Rezoning Transportation Analysis
Petition Number: Insert Zoning Petition #2021-012
General Location Identifier: Tax ID 10304112

Revision Log:	Date	Description
	02-25-2021	First Review (WB)
	03-25-2021	Second Review (WB)

SCHEMATIC
SITE PLAN
SCALE: 1" = 30'

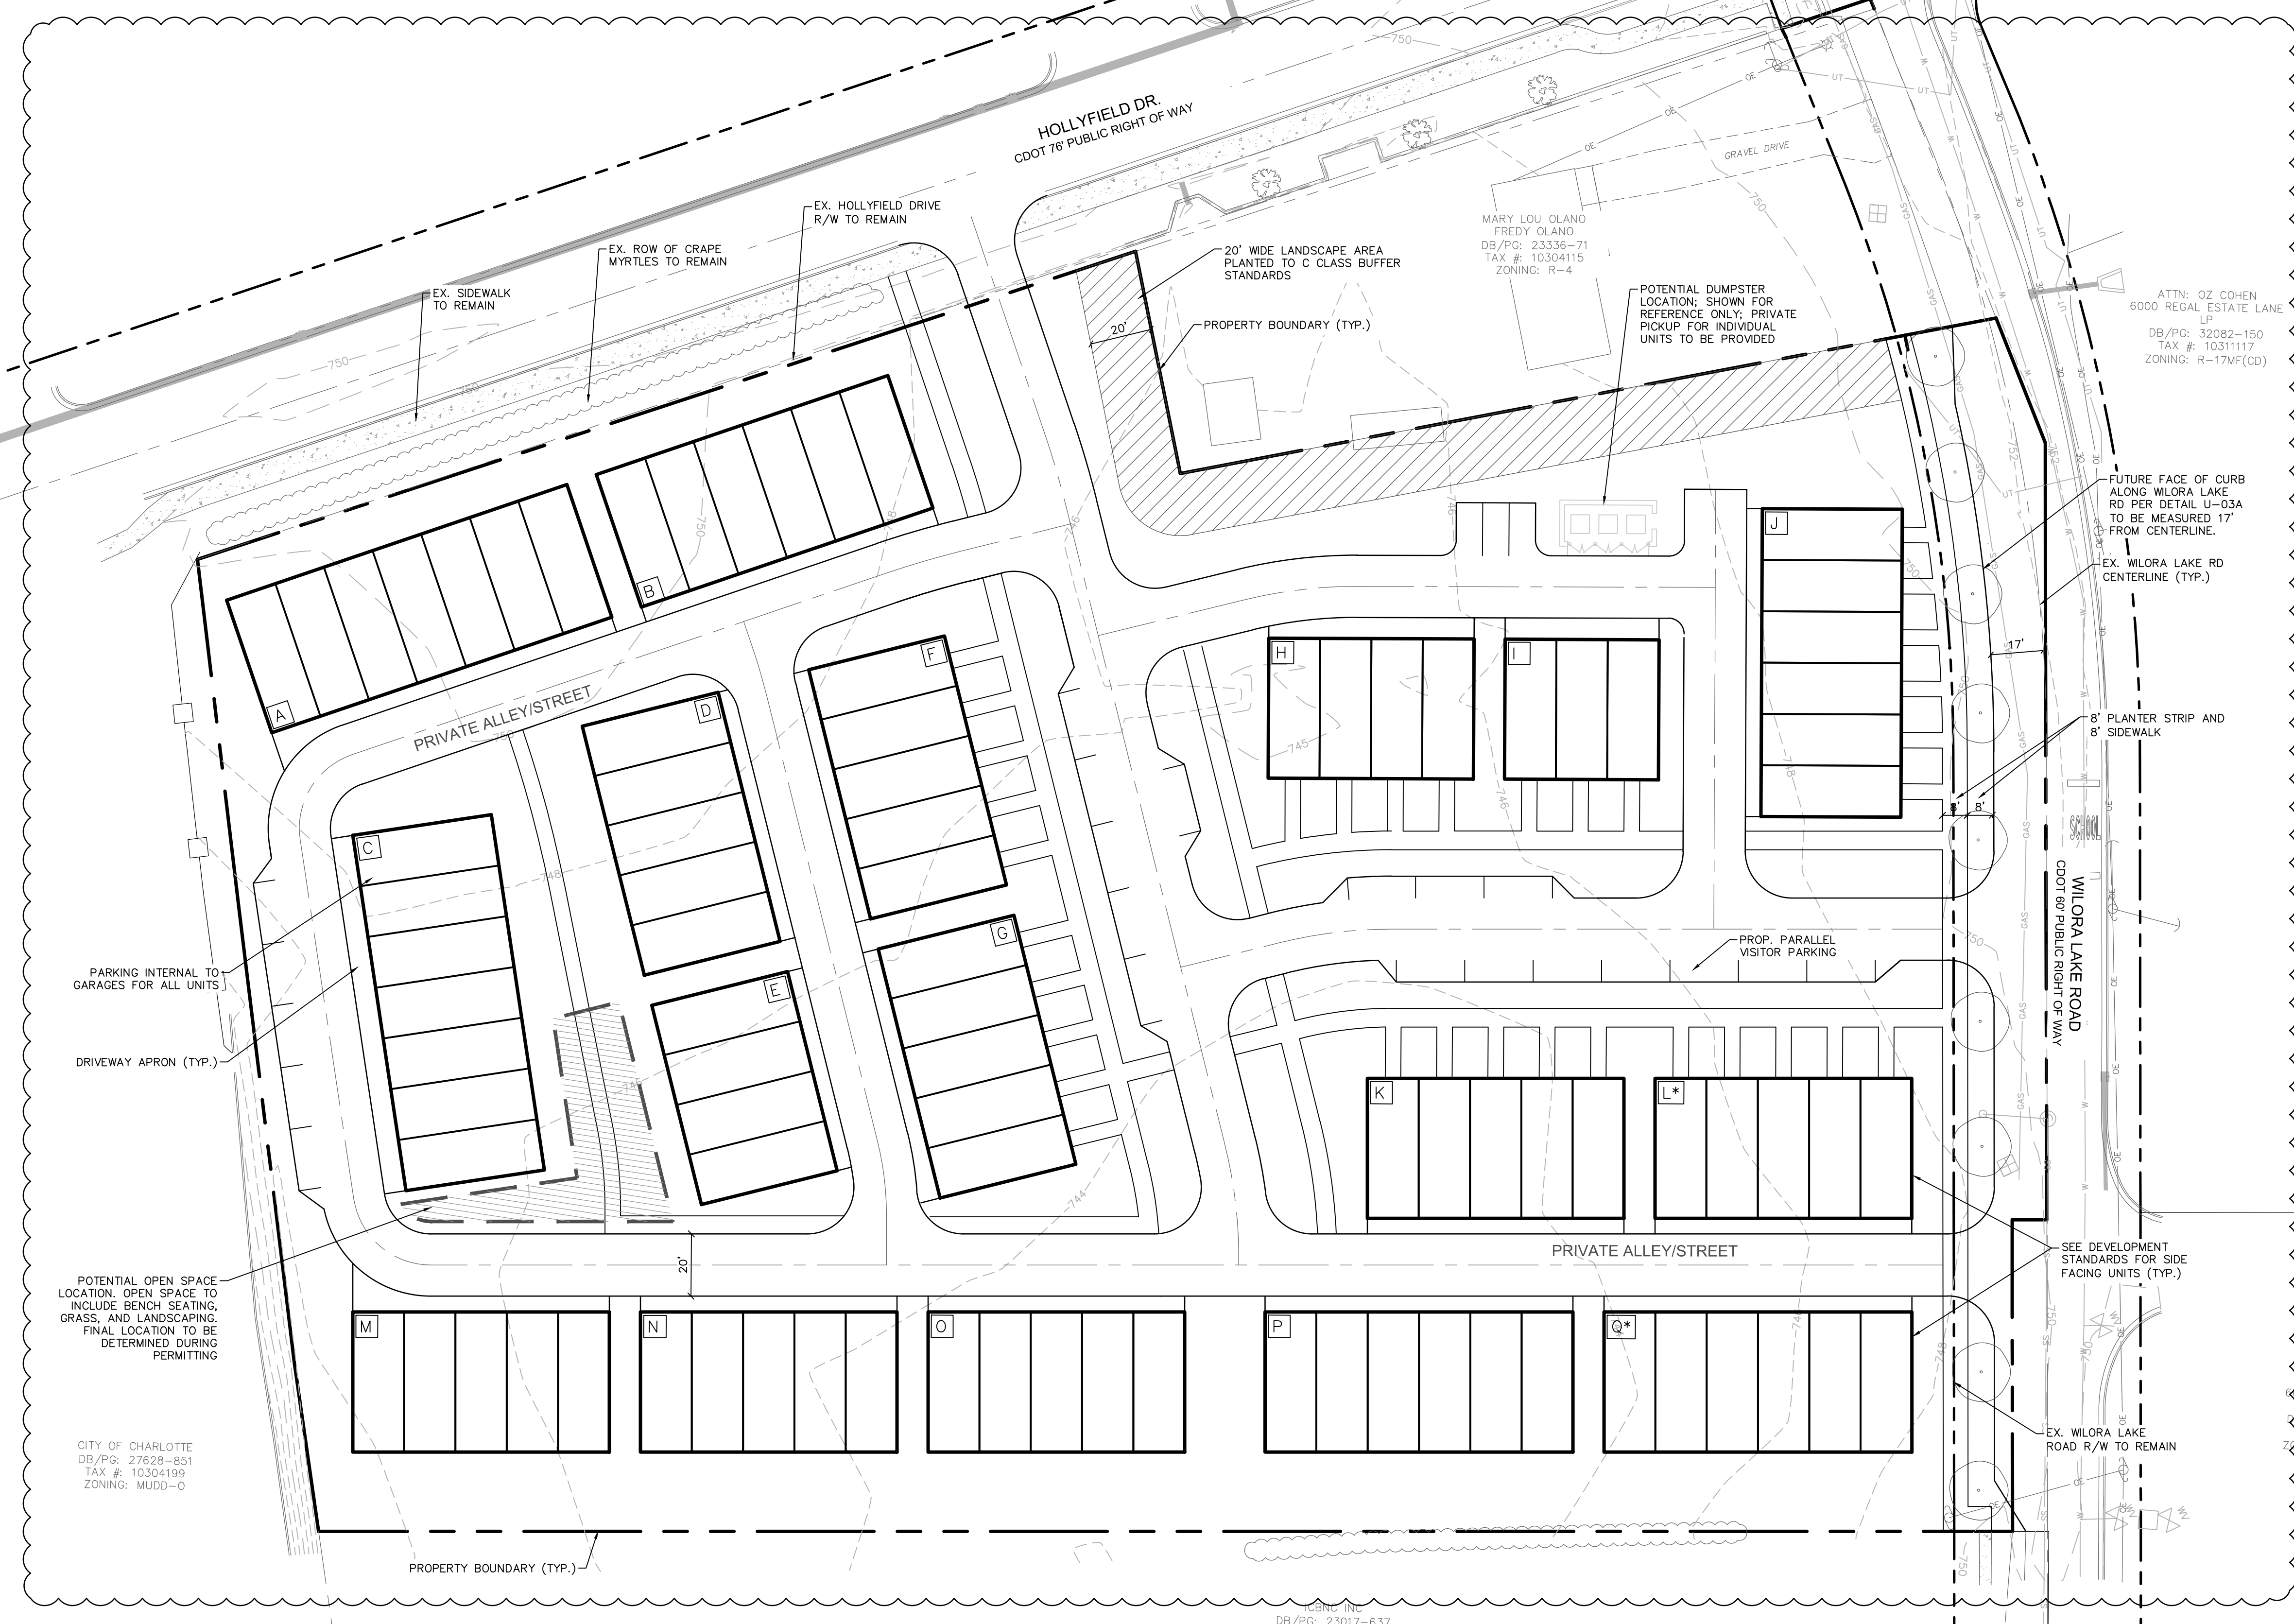
1. **Curblines:** The proposed zoning district has a setback measured from back of the existing or proposed future curblines.
 - a. **Wilora Lake Road:** The curb and gutter needs to be at 17.5 feet from the Wilora Lake Road centerline.

Label and dimension the back of curb and gutter from the road centerline.

- 3. The site plan commits to construct an 8-foot planting strip, 8-foot sidewalk along the site's Wilora Lake Road frontage leaving a sidewalk gap of less than 100' north of the site. Revise site plan and conditional note(s) to commit to extend the proposed 8-foot planting strip and 8-foot sidewalk to the Hollyfield drive intersection and tie into the newly constructed ADA curb ramps to assist CDOT in close a gap in pedestrian infrastructure.

The site plan shall label and dimension both items from the back of curb and gutter.
